Re: Ulan West Longwall 7 Infrastructure First Workings Request

Figure 1: Site plan of proposed variation to first workings for Longwall 7.

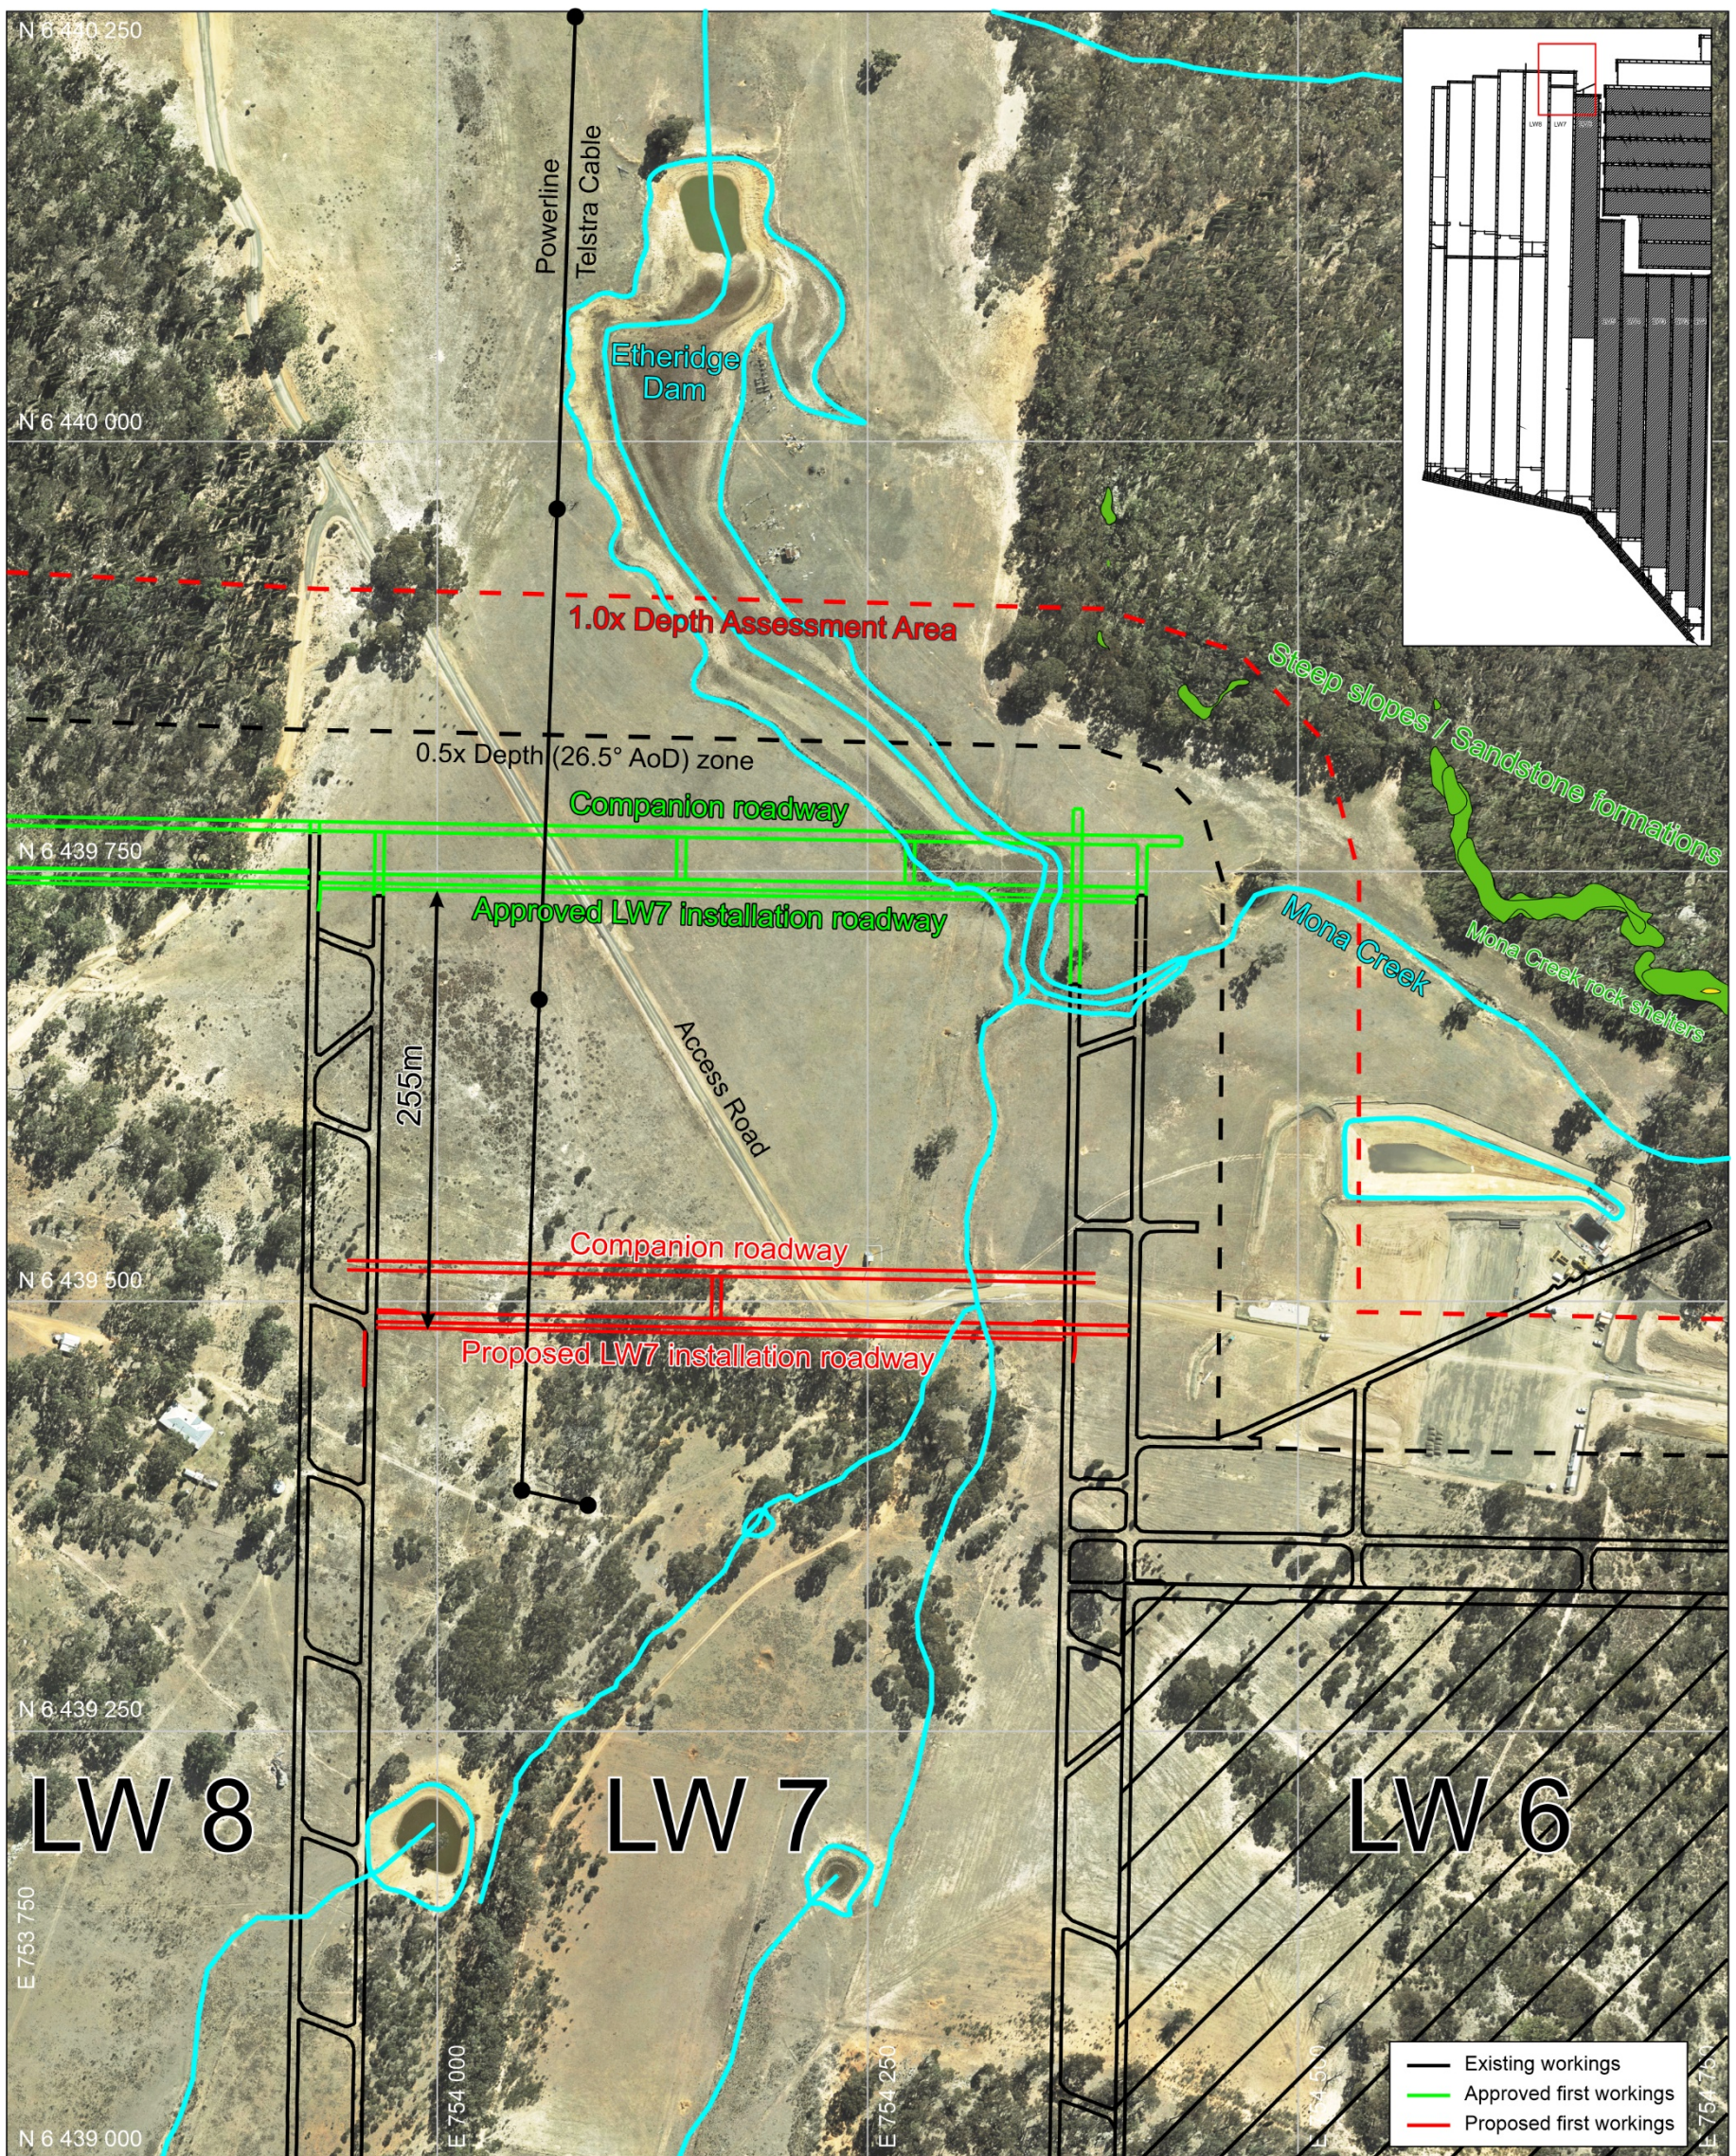
I am writing to request approval for a change to the approved first workings at Ulan West Operations (UWO), Long Wall (LW) 7. The proposed first workings amendment involves relocation of the installation roadway on the northern end of LW 7 to the south due to unfavourable mining conditions being identified at the location of the originally planned Installation Roadway position.

The proposed amendments to the first workings are shown in Figure 1, in Attachment 1 and involve relocating the installation roadway on the northern end of LW 7 to the south, by 255 metres. The proposed first workings amendments follow detailed geotechnical evaluations which reassessed the risk at the original planned installation roadway position. This identified that the continuation of mining and specifically formation of wide roadways within this area poses increased health and safety and financial risk to the mining operation. Moving the LW 7 installation roadway position to a more suitable location to the south by 255m significantly reduces these risks.
